Bowland Forest Lower Division Parish Council

15th August 2012

At a meeting of the above council with regard to planning permission application no: 3/2012/0561 submitted by Mrs Angela Porter for proposed engineering operations to form earth banked slurry lagoon and laying of concrete railway sleepers to form cow track across land at Hodder Bank Farm, Dunsop Road, Whitewell BB7 3AU.

PROPOSED TRACK 466M LONG AND 1.8M WIDE

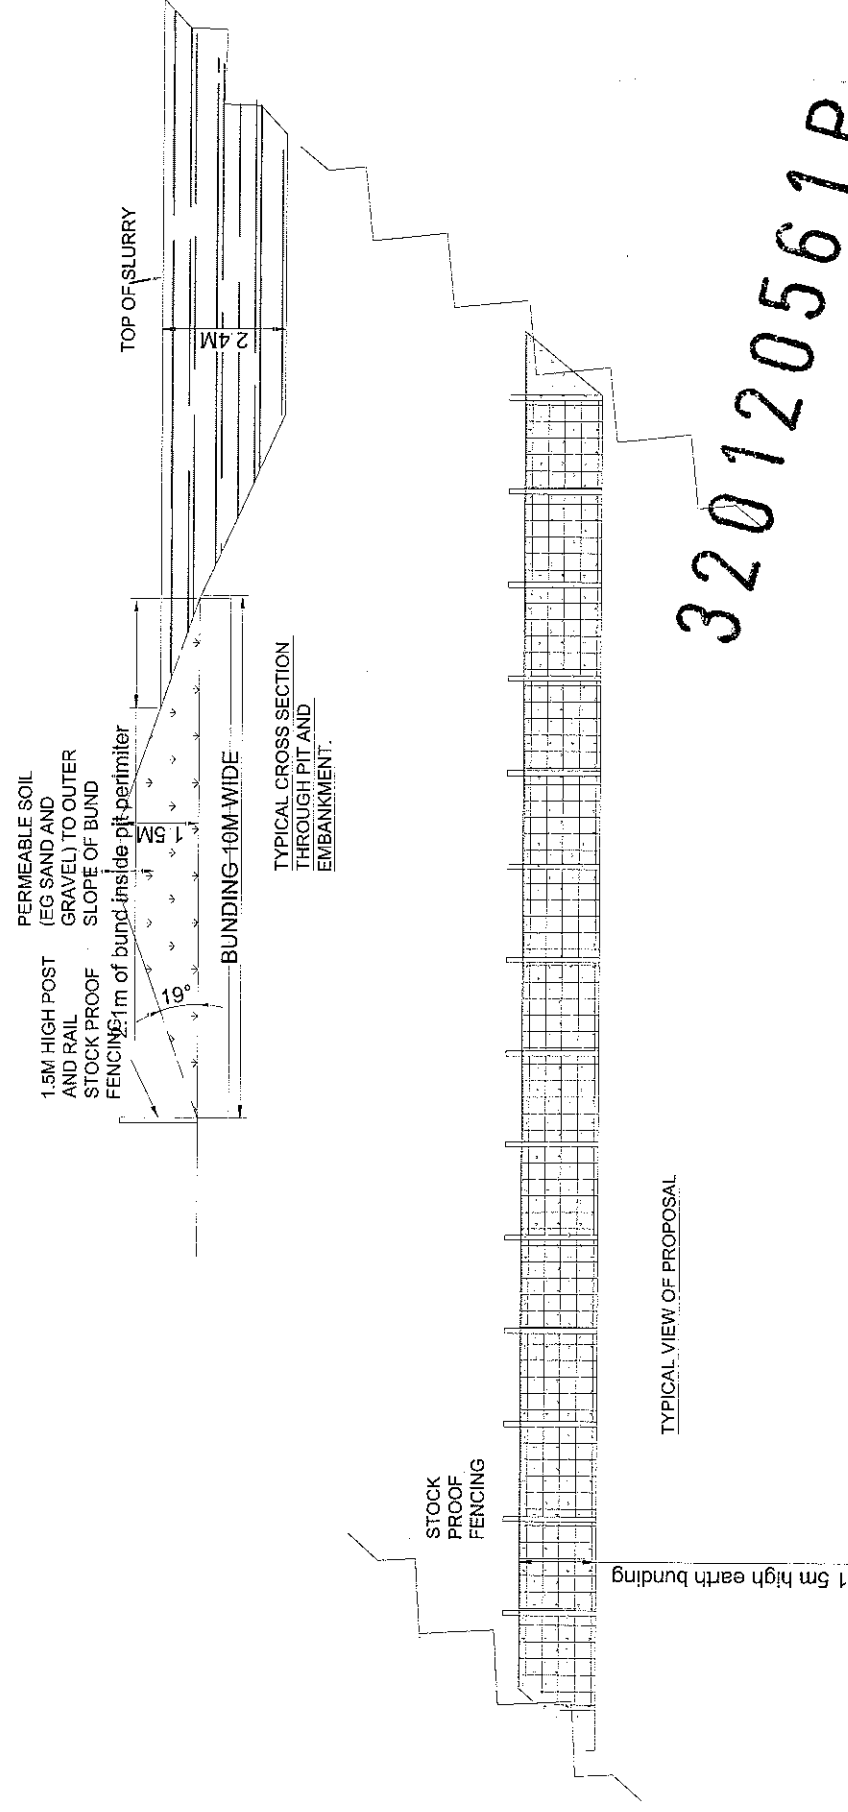
After a discussion and inspection of the plans, whilst the councillors have no objections to the plans, the following problem should be addressed and should be a condition of the granting planning approval Surface water runs down the track and over the cattle grid onto the main road and we feel this should be addressed in order that any seepage from the lagoon does not mix with the surface water This problem has existed for a number of years and has not been rectified
